FAO Case Officer
Planning
Objection re 2020/92284

The application:

PROPOSED PLAN OF STUDIO/OFFICE 1:50 @ A2

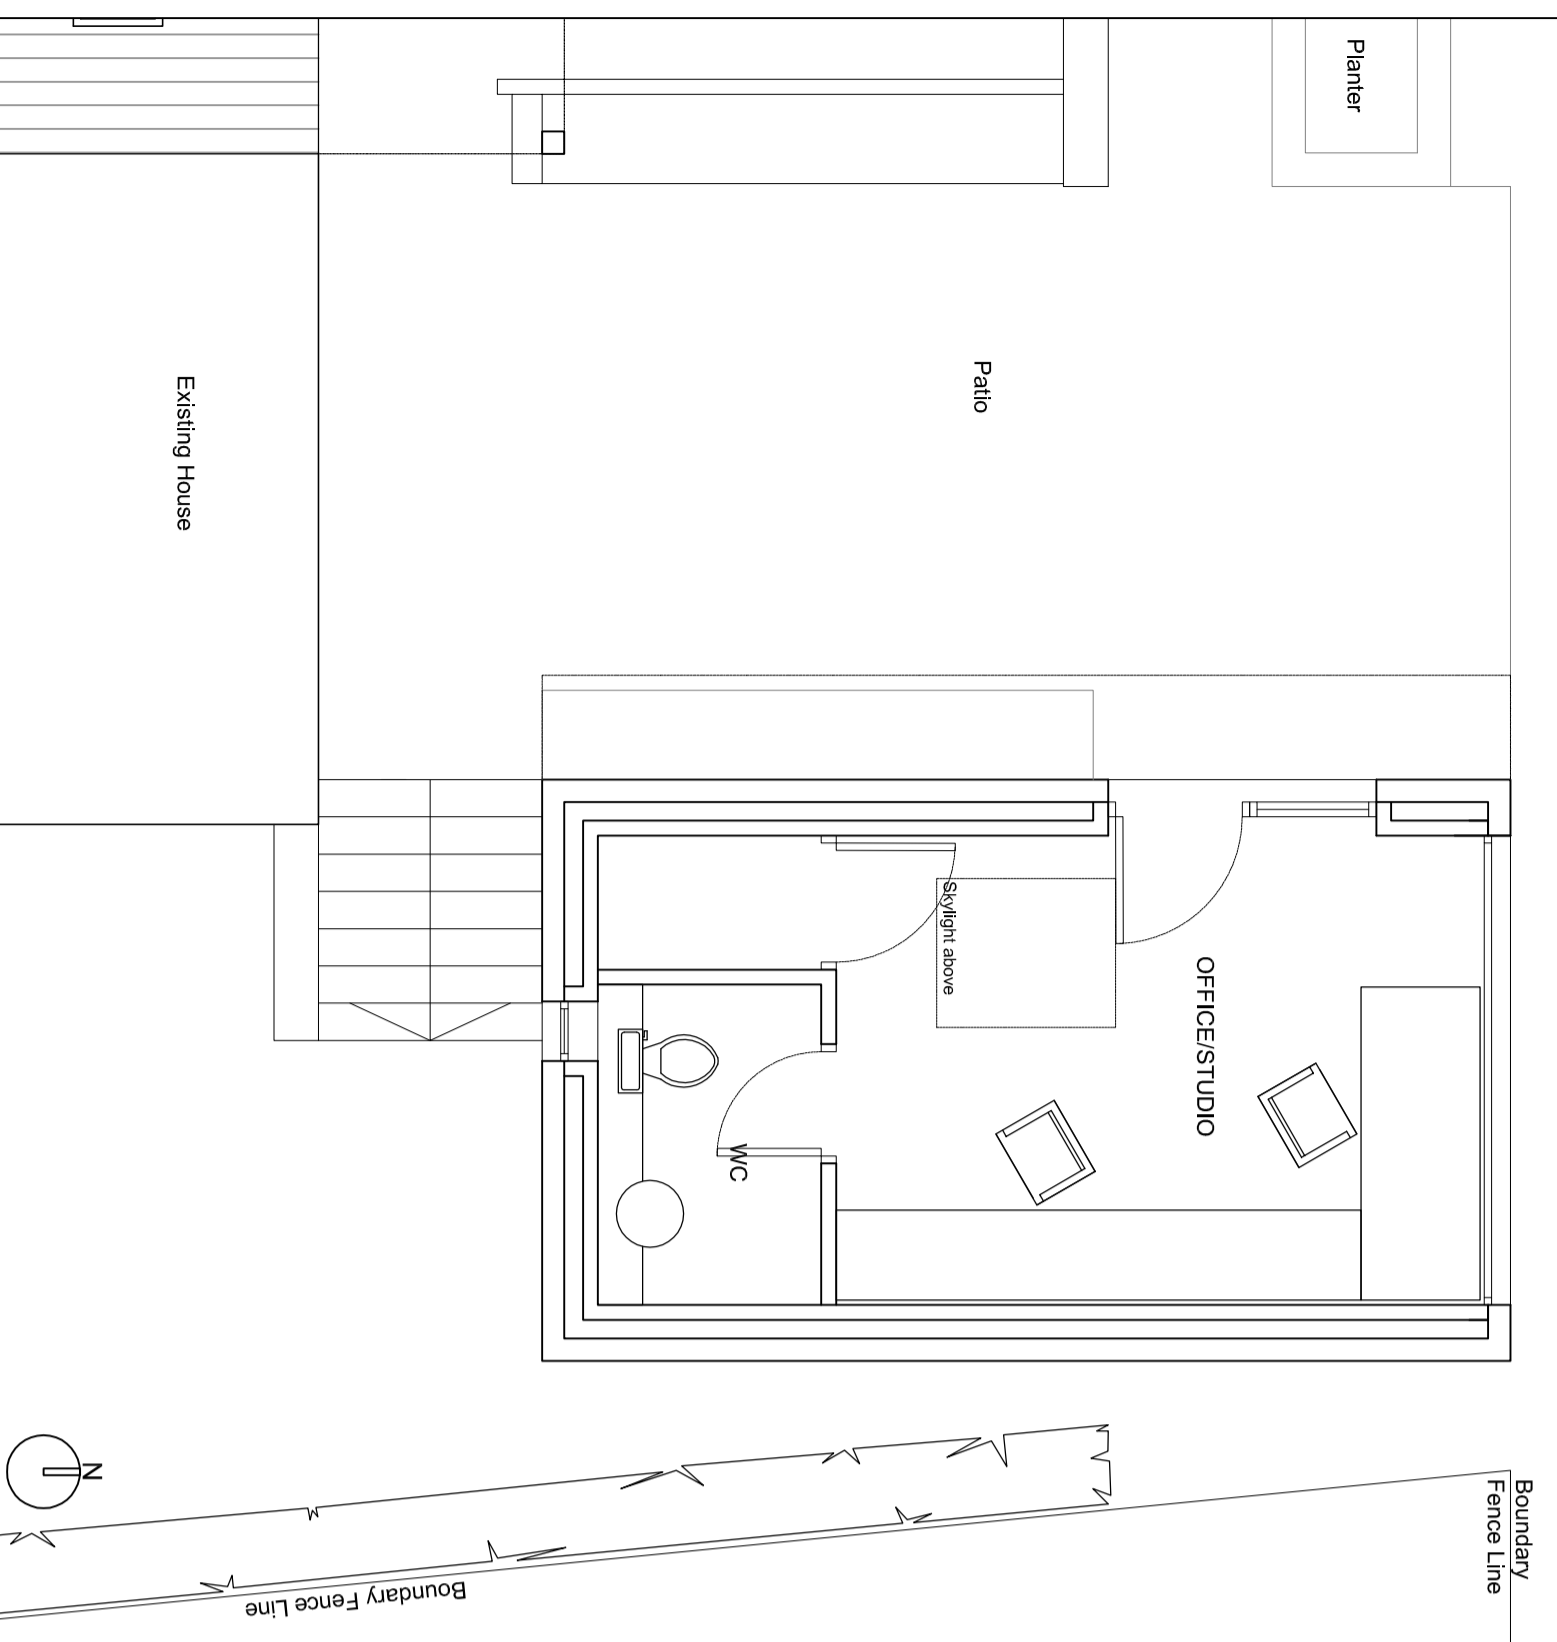
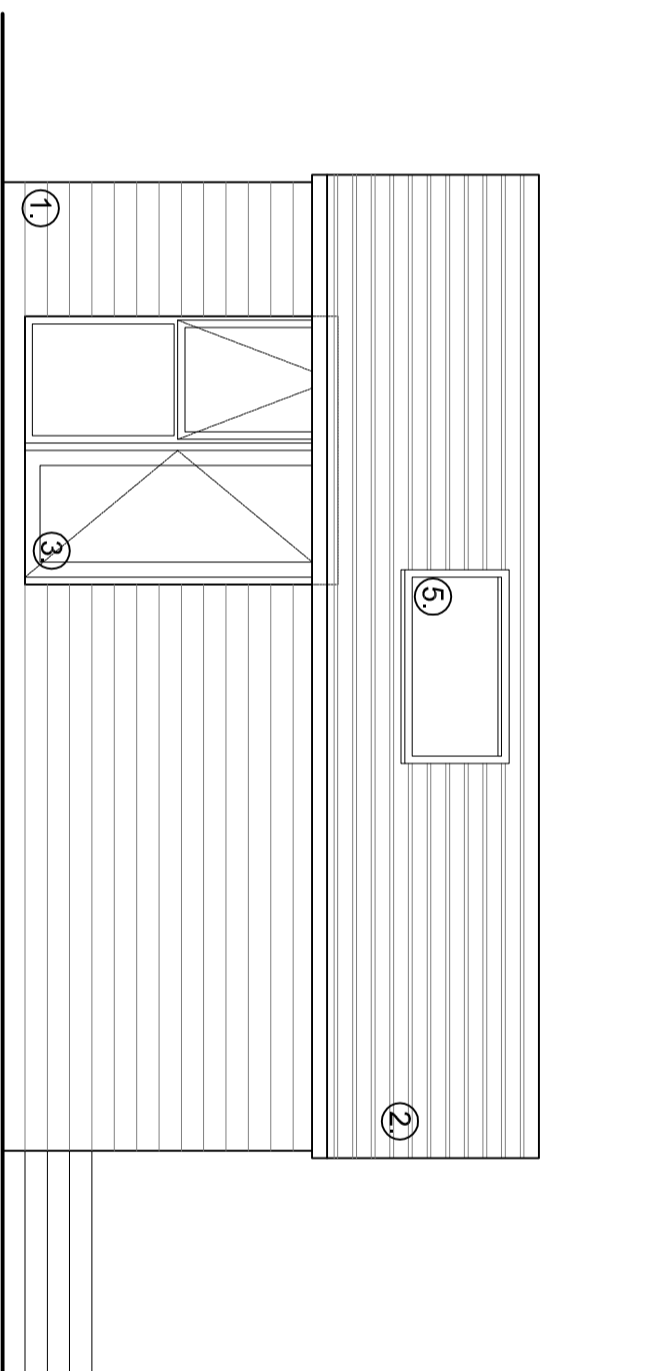
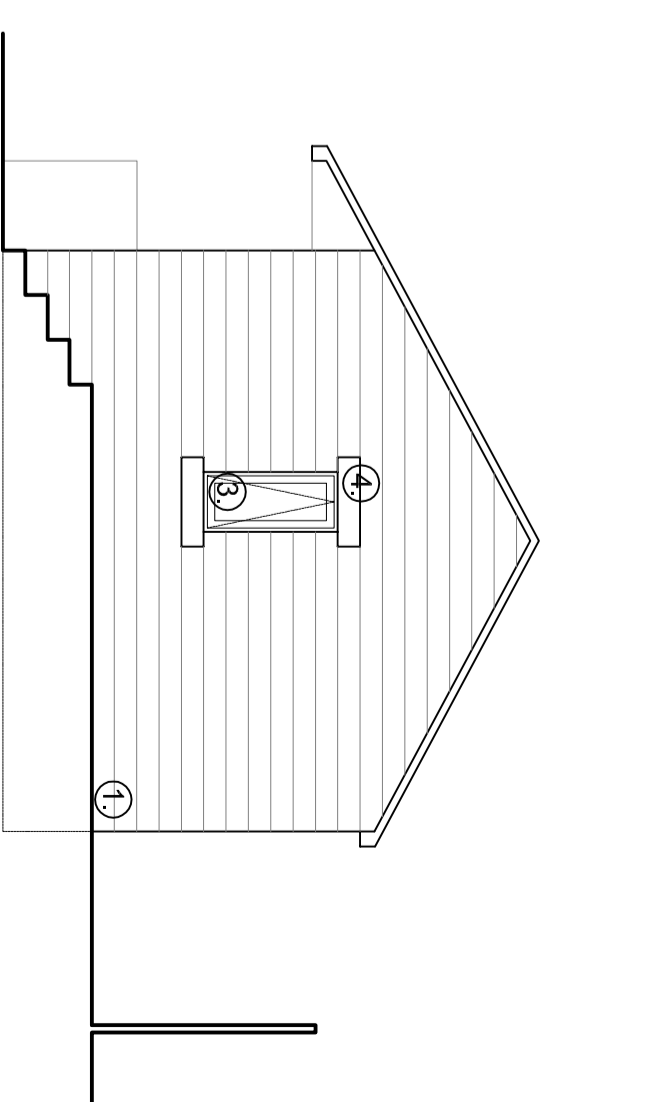
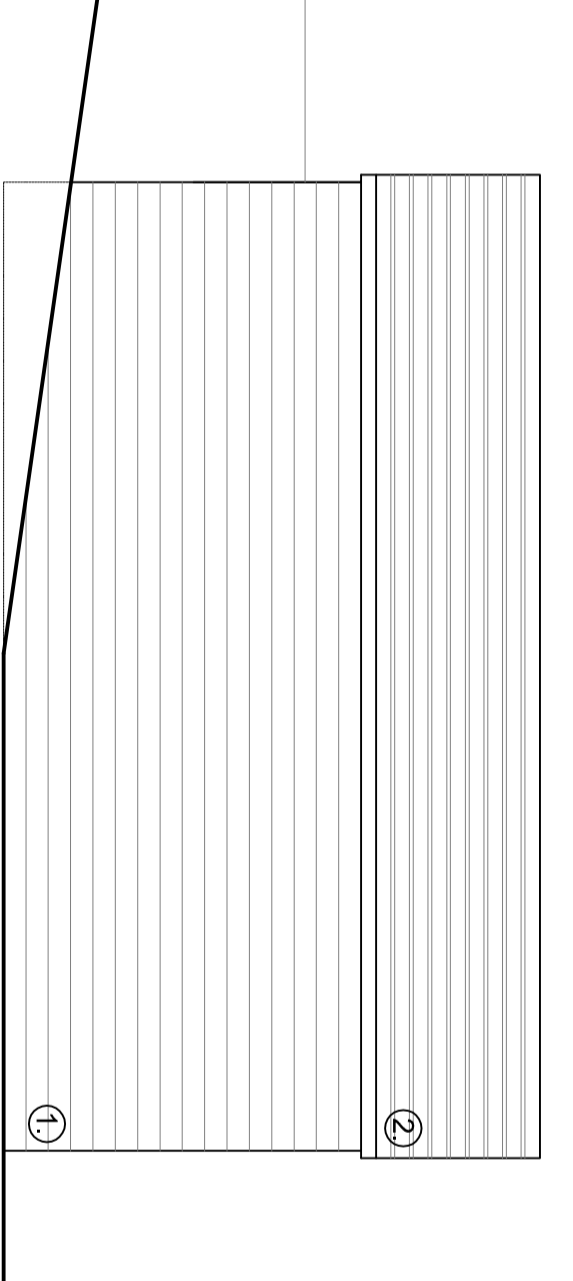
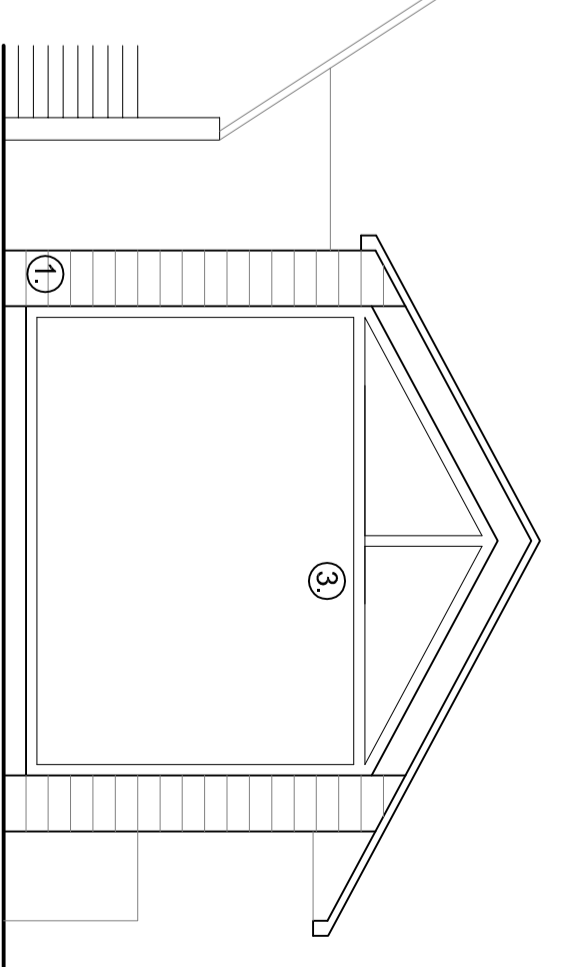
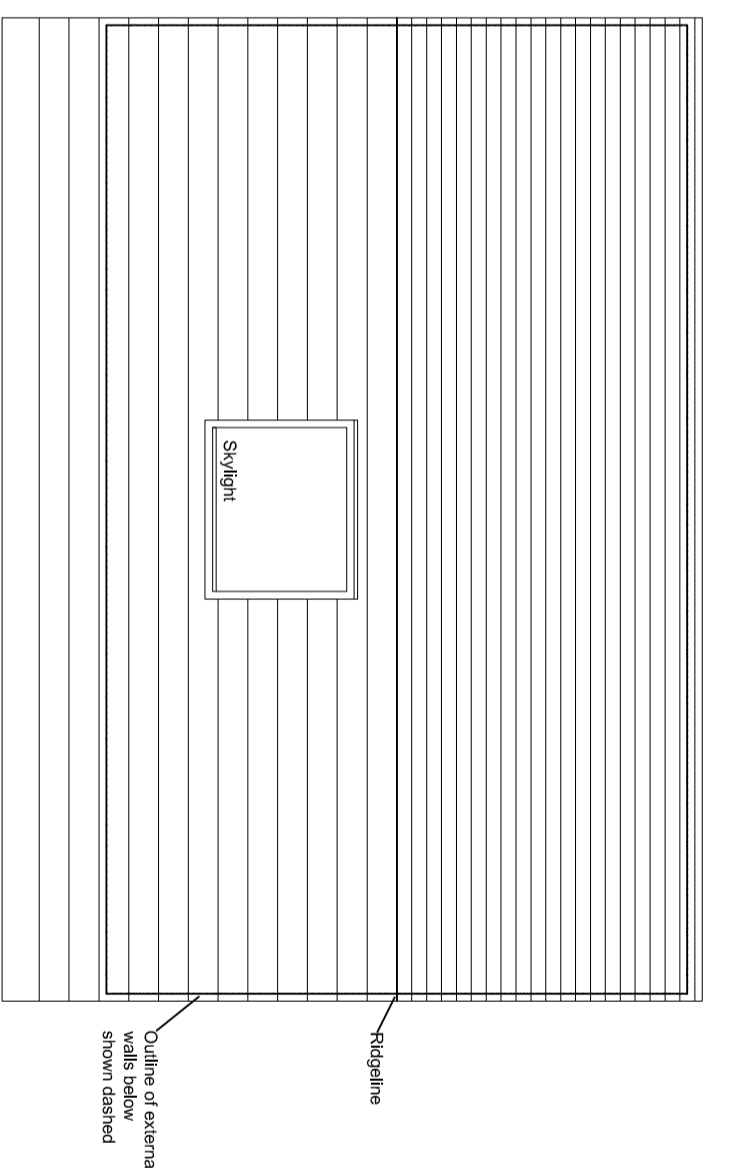
The application claims the materials match those of the existing property. This is incorrect. The original building is constructed of coursed natural stone. The use of materials matching the original building was a condition of an approval under application 2019/92330. A variation of the condition remains open under 2020/91774. The original condition should not be varied, and the current application should be refused.
